Sheringham Shoal and Dudgeon Offshore Wind Farm Extension Projects

Draft Statement of Common Ground with National Highways (Revision C)

Revision C
Deadline 5
June 2023
Document Reference: 12.22

▨ VEHICLE BODY SWEEP PATH (FORWARD GEAR)  
 — VEHICLE CHASSIS SWEEP PATH

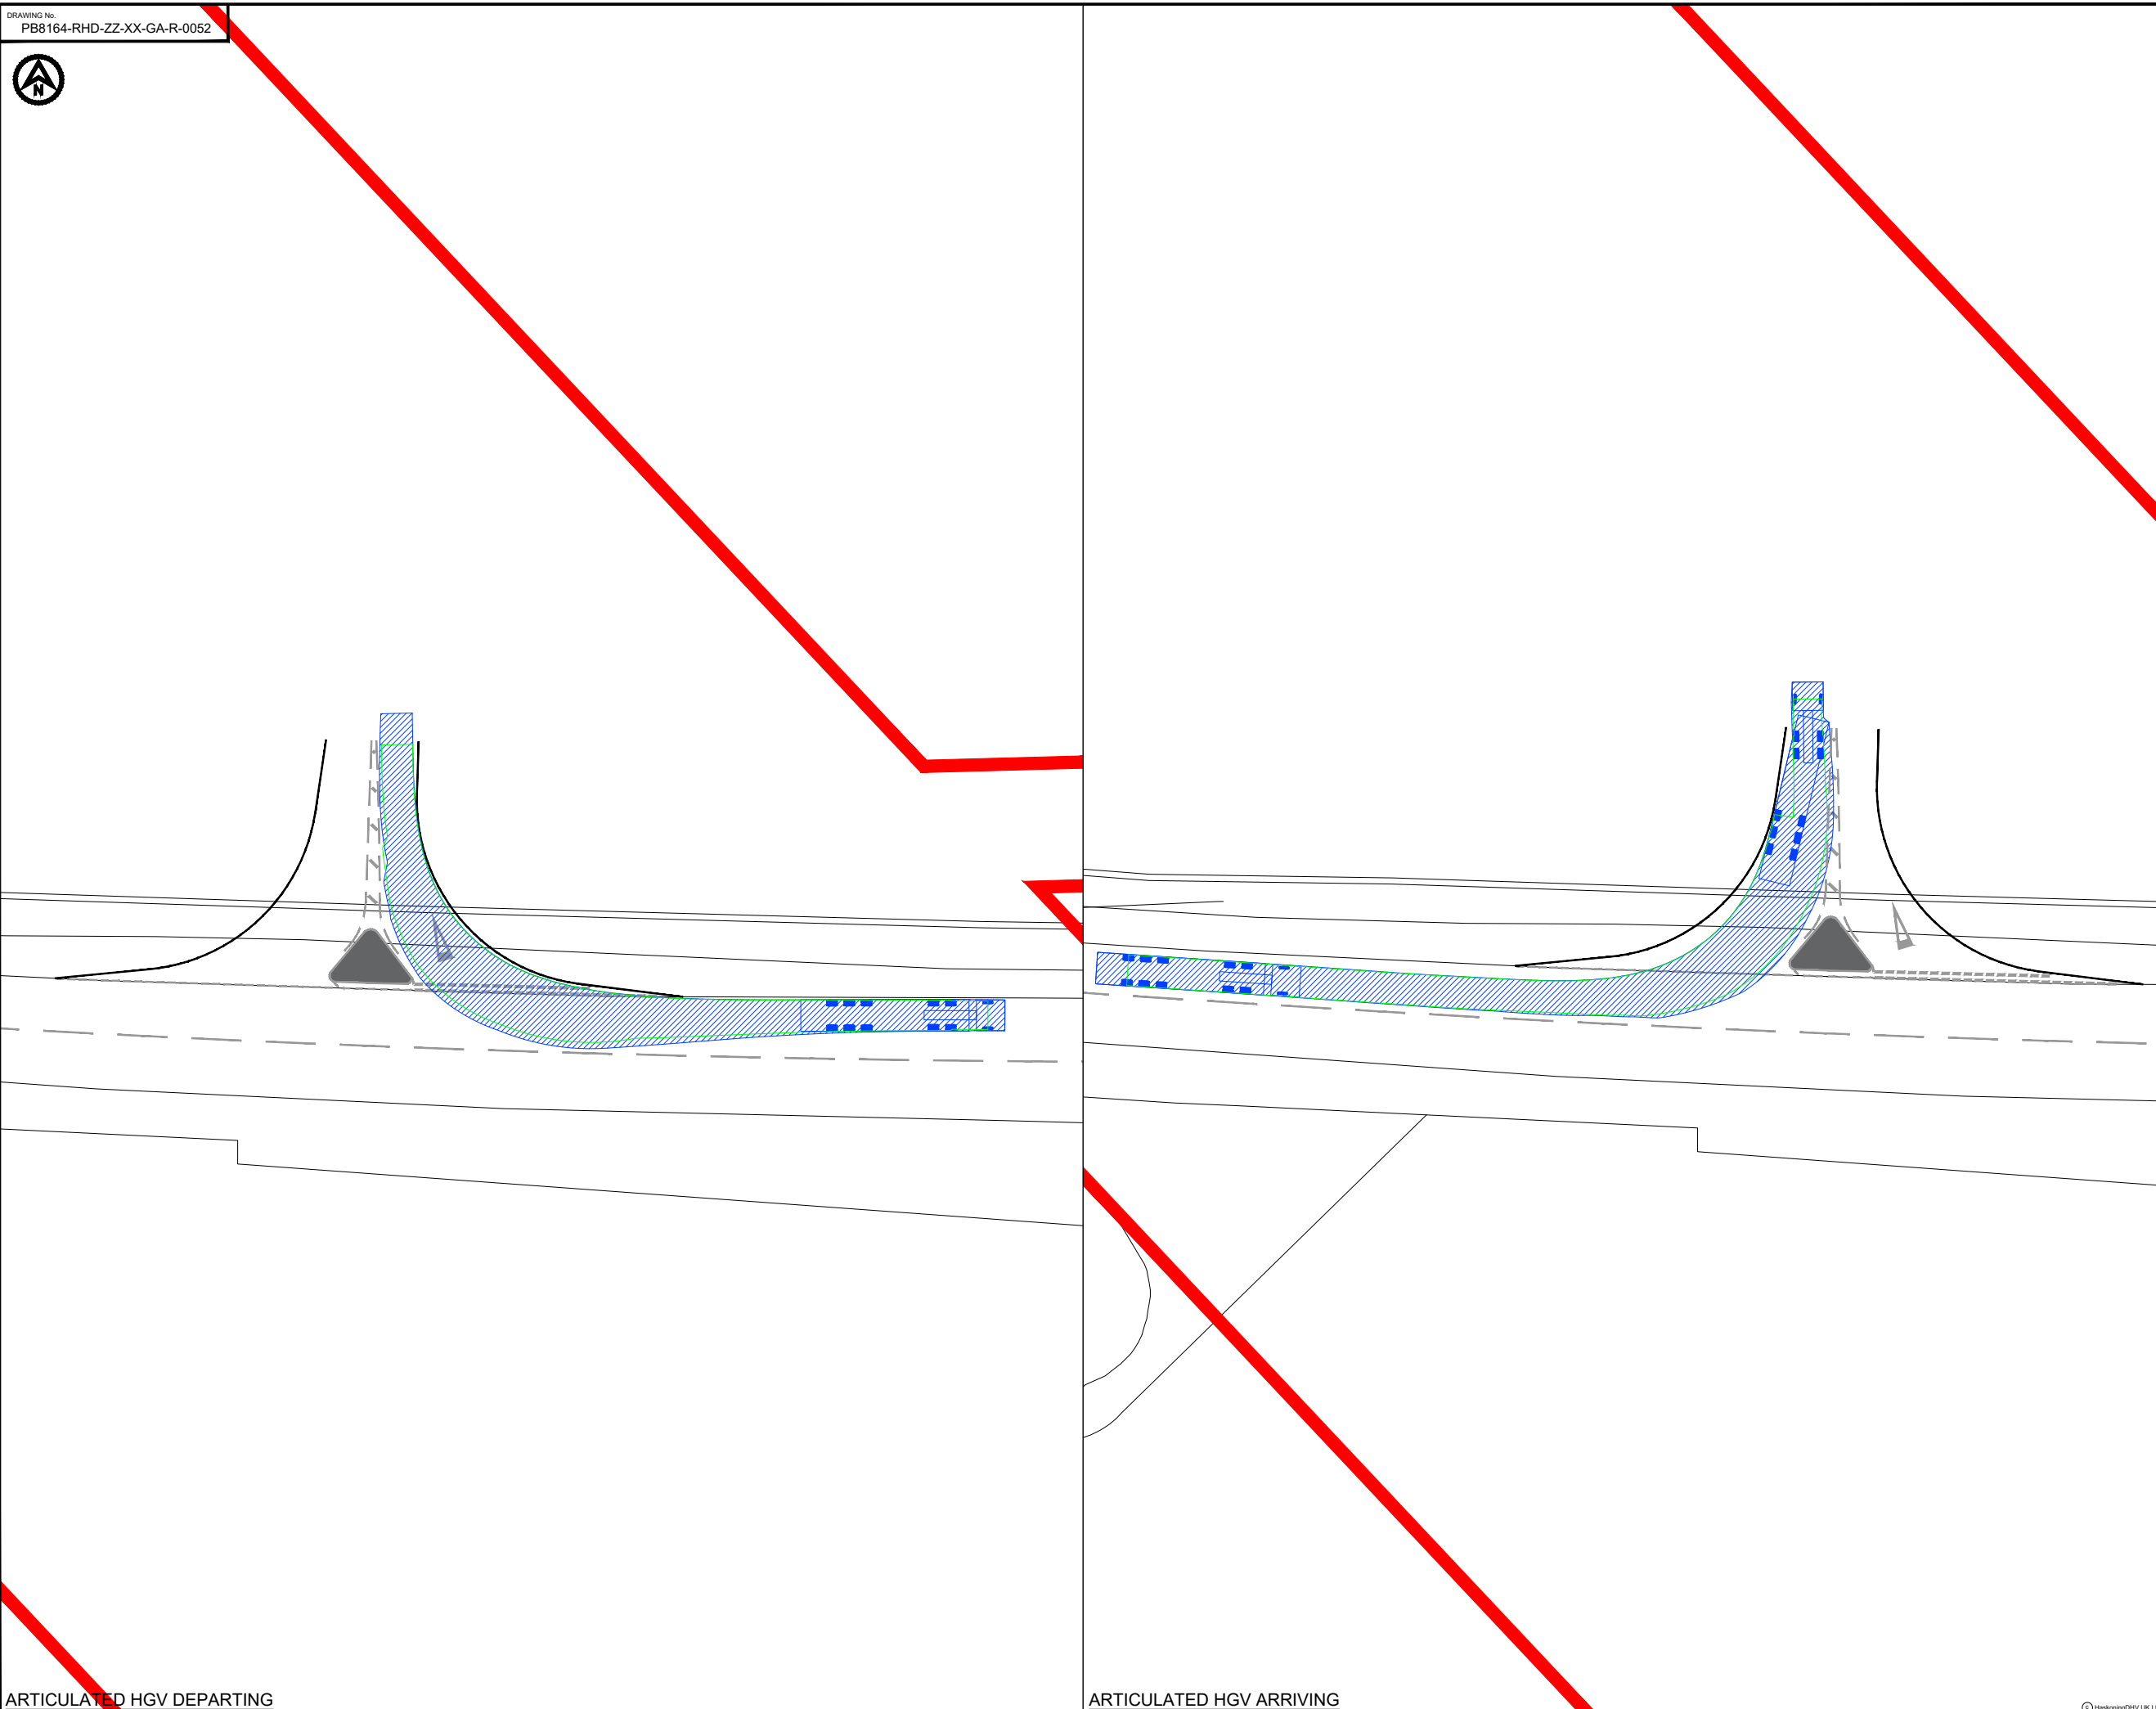
23	The outline design for an access off the A47 is appropriate, as presented in Annex 30 of the Transport Assessment [APP-268 and APP-269]	National Highways agree that the outline design for an access off the A47 (ACC47) is appropriate subject to Stage 1 and 2 Road Safety Audits being carried out post consent. Please note that this access is only usable until the A47 Tuddenham scheme starts construction, or if the A47 Scheme does not go ahead.	<i>Agreed</i>
EIA – Cumulative Impact Assessment (CIA) Conclusions

ID	The Applicant Position	National Highways Position	Position Summary
		mitigate likely significant impacts identified in the ES Chapter 24 Traffic and Transport [APP-110] for all other impacts.	
29	The access concept design for access ACC47 is appropriate and that detailed access designs can be developed and agreed with National Highways prior to the start of construction, secured under Requirement 16 of the draft DCO [AS-009].	National Highways agree that the access concept design for access ACC47 is appropriate, subject to Stage 1 and 2 Road Safety Audits to be carried out post consent, and that detailed designs can be developed and agreed with National Highways prior to the start of construction, secured under Requirement 16 of the draft DCO.	<i>Agreed</i>
30	The monitoring procedures set out in the OCTMP (Revision D) [document reference 9.16] are appropriate.	National Highways have requested further amendments to the OCTMP to include a monitoring group that is set up and chaired by the Applicant which will consider whether the CTMP is being carried out and working. The Applicant and National Highways have agreed at a meeting on the (06/06/2023) that the Monitoring Group will include a review of the outputs of the Monitoring Report and discuss any remedial measures. These amendments will be captured within Revision D of the OCTMP at Deadline 5. National Highways position on this matter is reserved pending review of Revision D of the OCTMP at Deadline 5.	<i>In Discussion</i>
